From: Jonathan Fletcher
Sent: 16 November 2016 12:33
To: DCAdmin
Subject: FW: 2016/93160 - Land adj to 82 Healey Road

From: Mark Berry
Sent: 16 November 2016 11:23
To: Jonathan Fletcher
Cc: Highways DevelopmentControl
Subject: RE: 2016/93160 - Land adj to 82 Healey Road

As discussed the revised proposals are considered acceptable.

Drawing Number 1589 - D - 20 - 003
Revision A

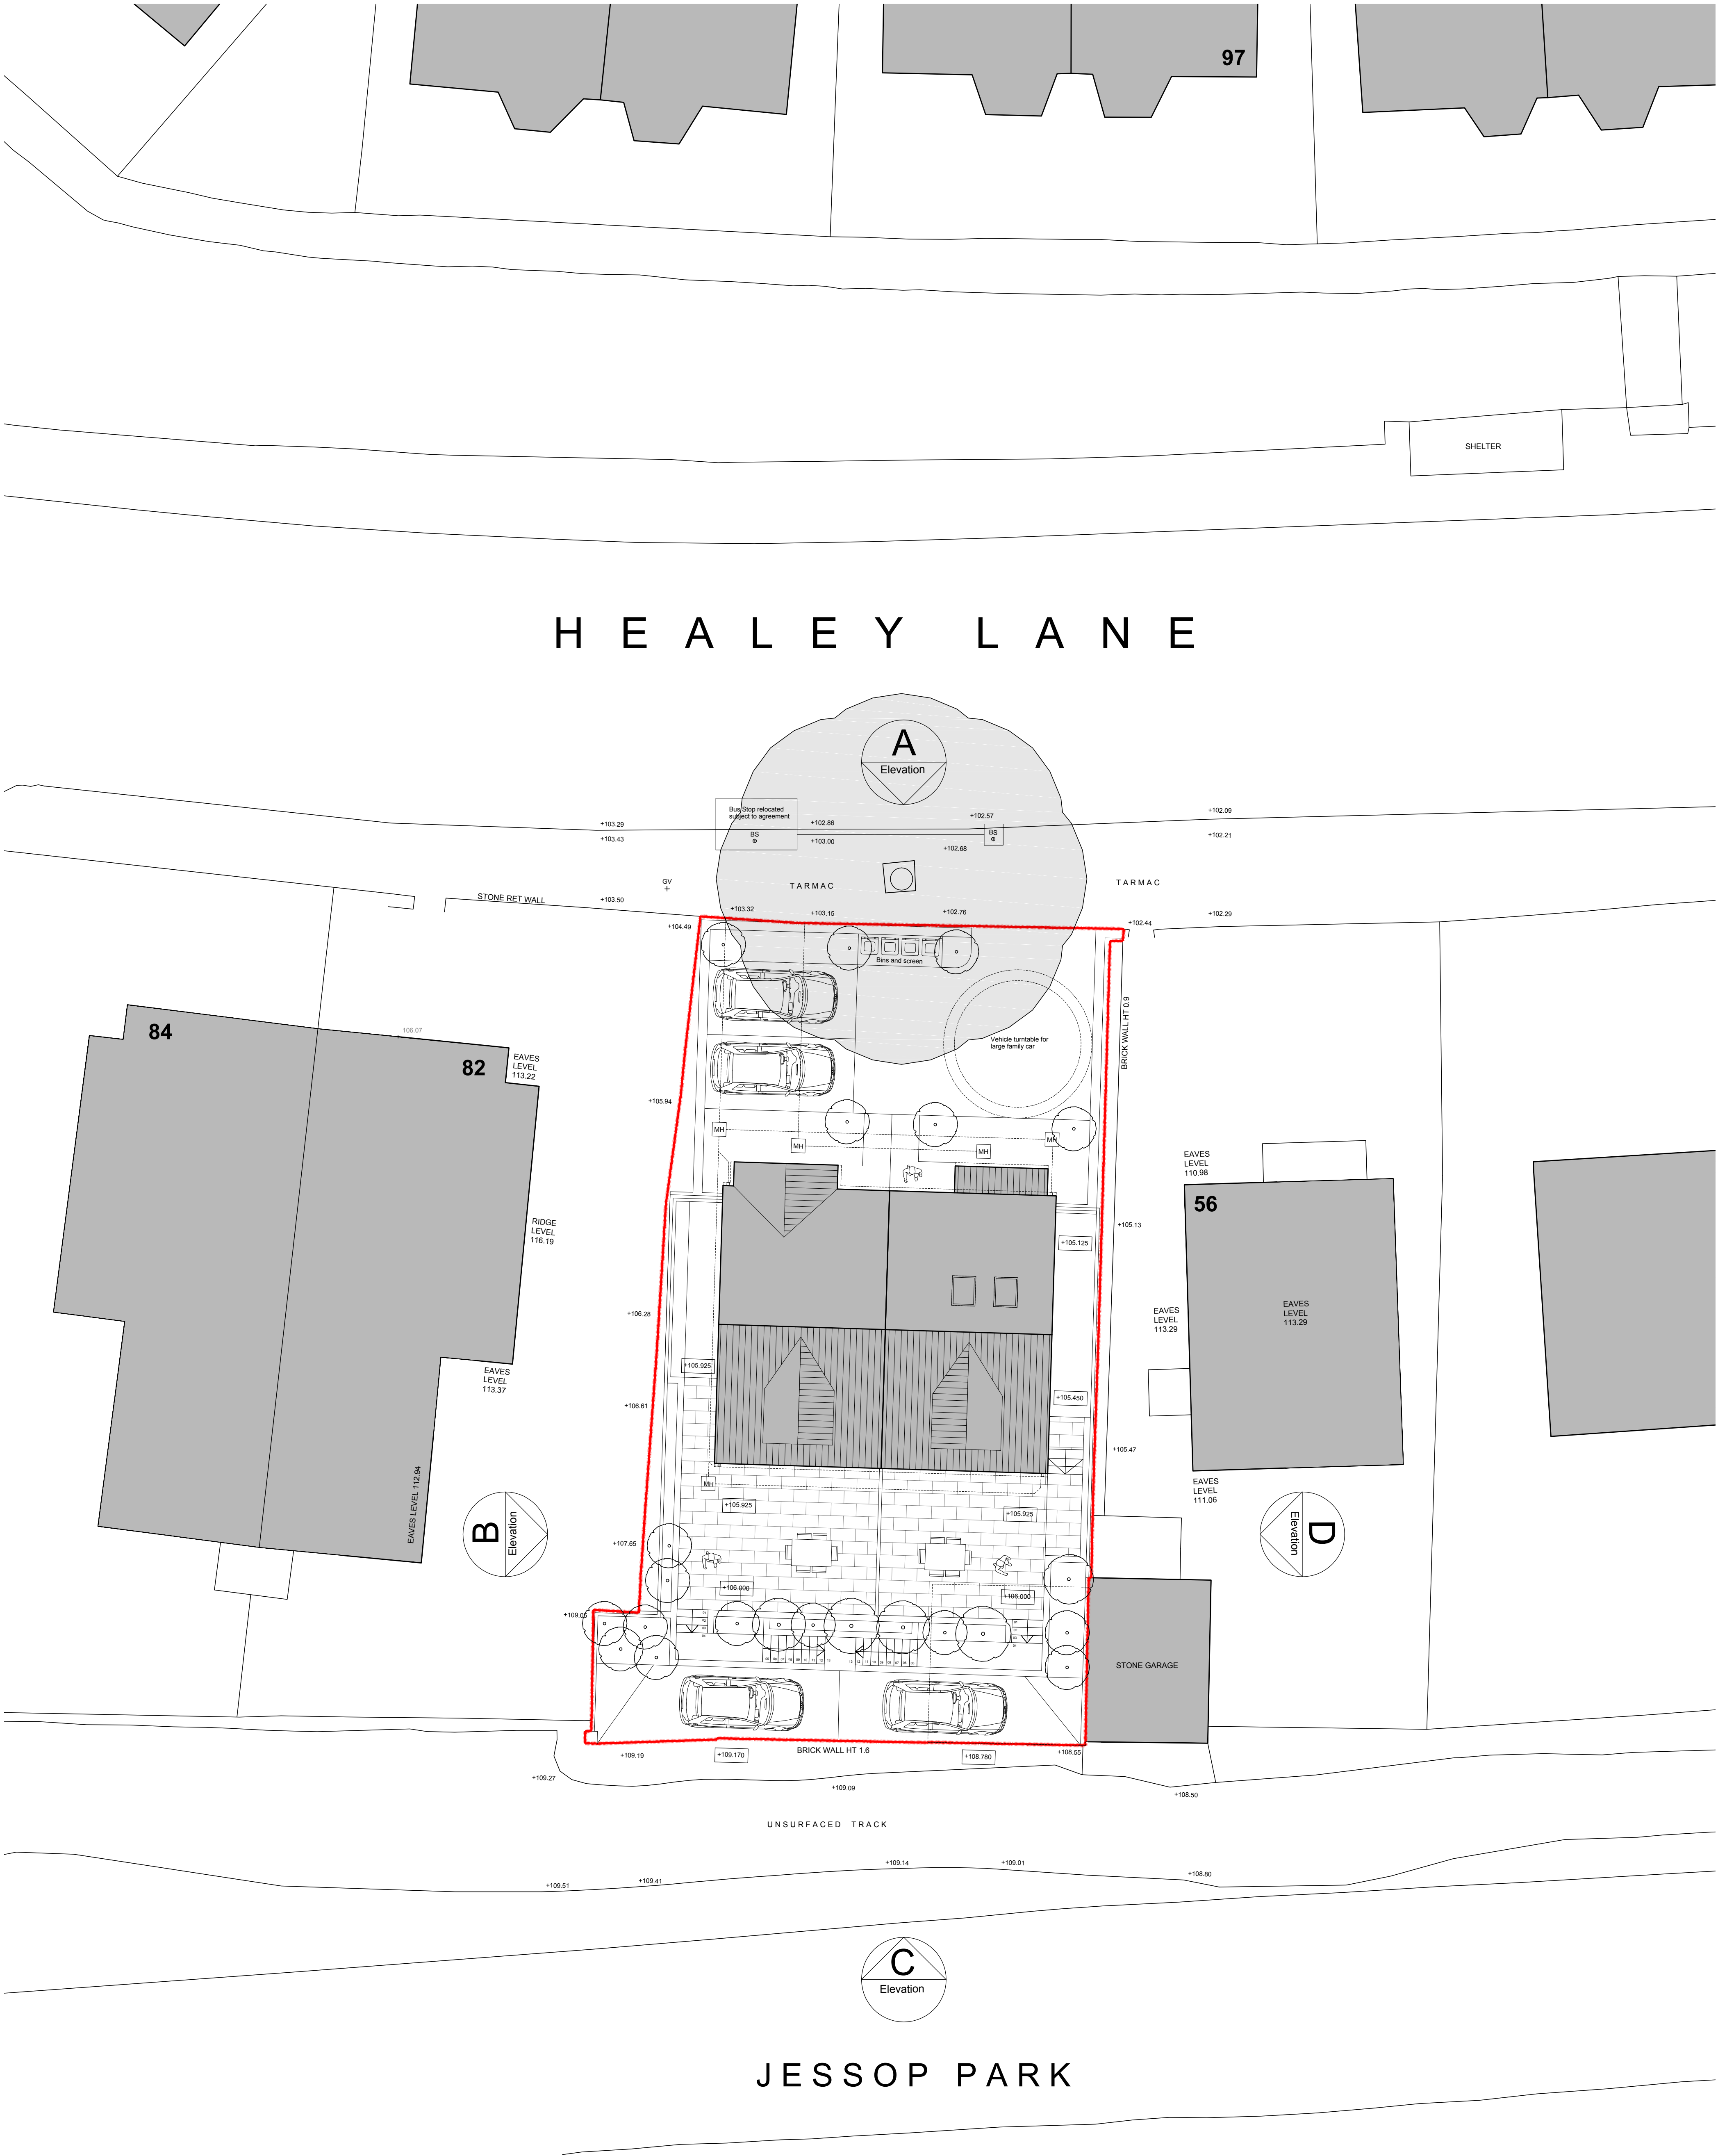
Turning facilities to be provided

Before any dwelling is occupied turning facilities shall be provided in accordance with the details shown on drawing no 1589-D-003-A. The turning facilities shall thereafter be made available for use at all times by vehicles and shall be kept free from obstruction to such use.
